Arun District Conservation Area Advisory Panel
c/o Civic Centre

17th May 2021

Application No: AB/40/21/HH
Site Address: Herricks School Lane Arundel BN18 9DR
Description of works: Repair and painting of the exterior walls, doors and windows to the front and rear elevation. (This application may affect the setting of the Arundel Conservation Area)
(This application may affect the setting of a Listed Building).

HERRICKS – FRONT ELEVATIONS

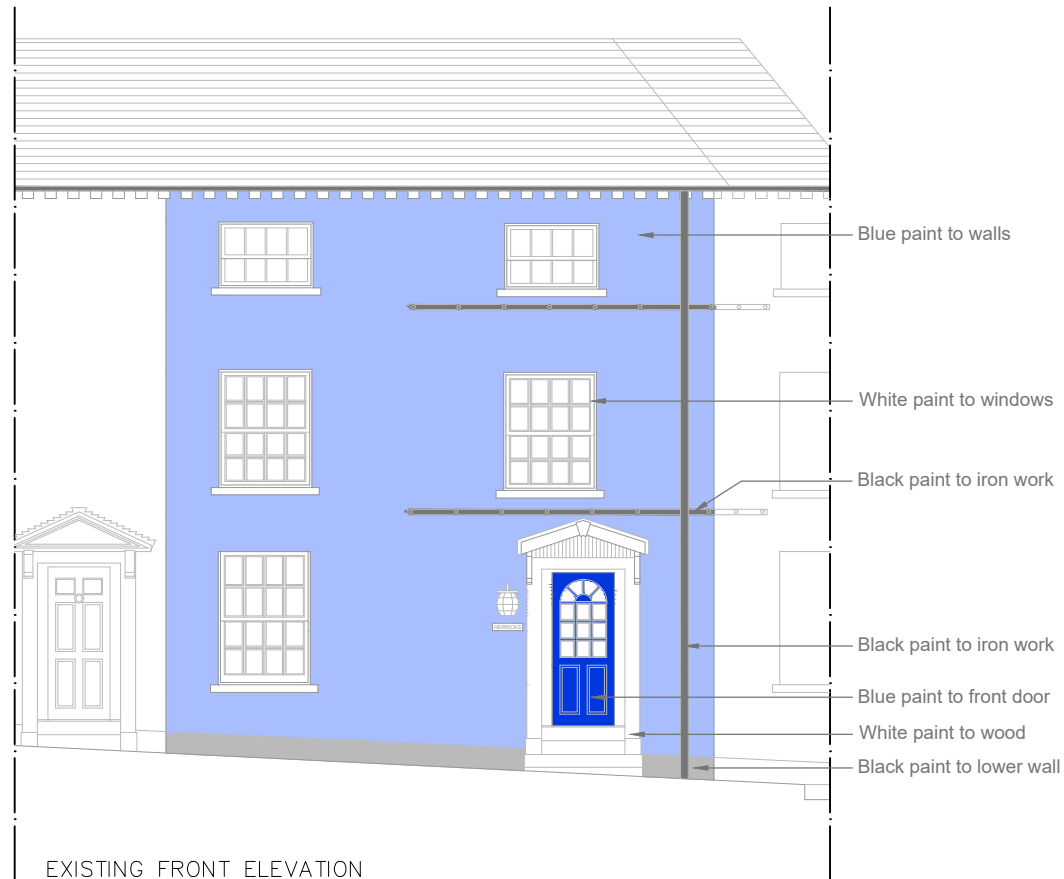
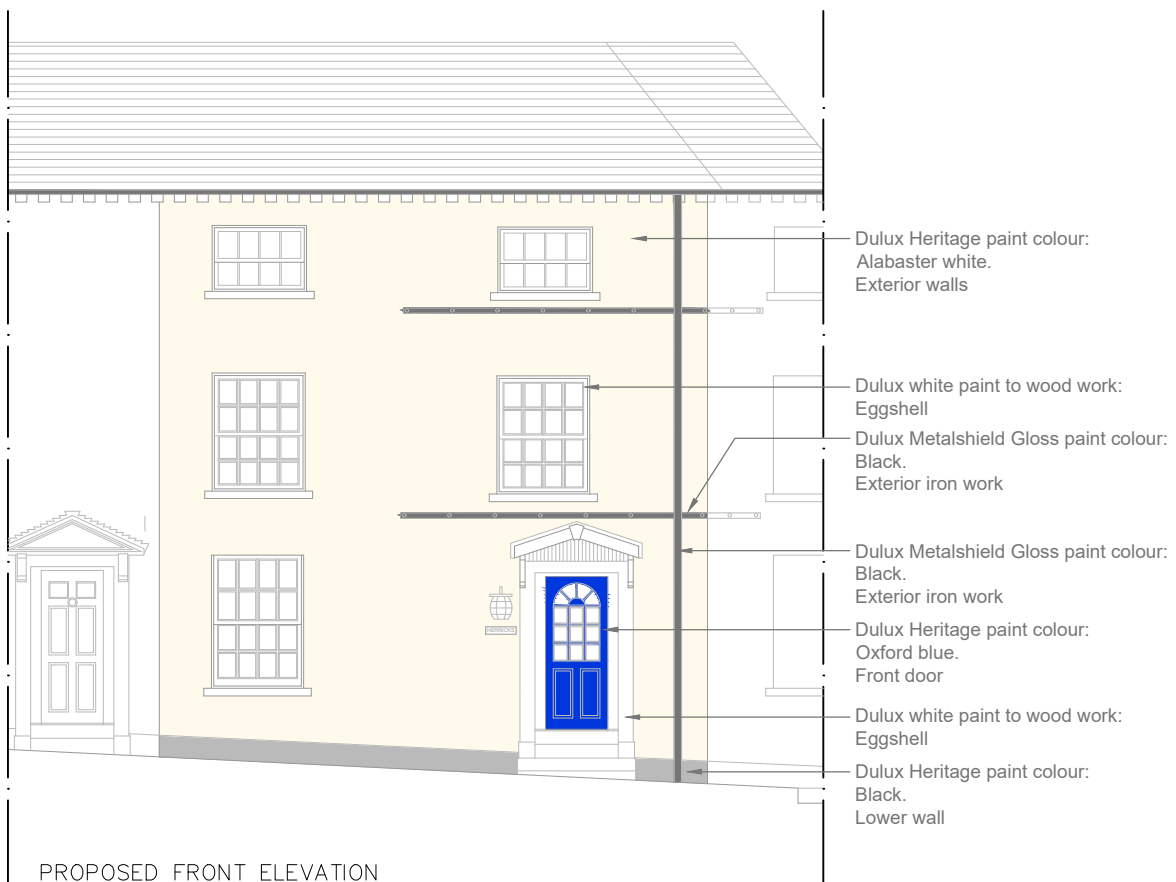
The change in colours are appropriate and should result in a visual enhancement to the building and indeed the group. There appears to be two heritage statements submitted with the application where the proposed front door colour is mentioned as Oxford Blue in one and Black in the other.

The existing front door is of an inappropriate design and there would be a further enhancement to the building and the group if it were replaced with a six panel door to match those on the adjoining dwellings although it is appreciated that the Council cannot insist on this.
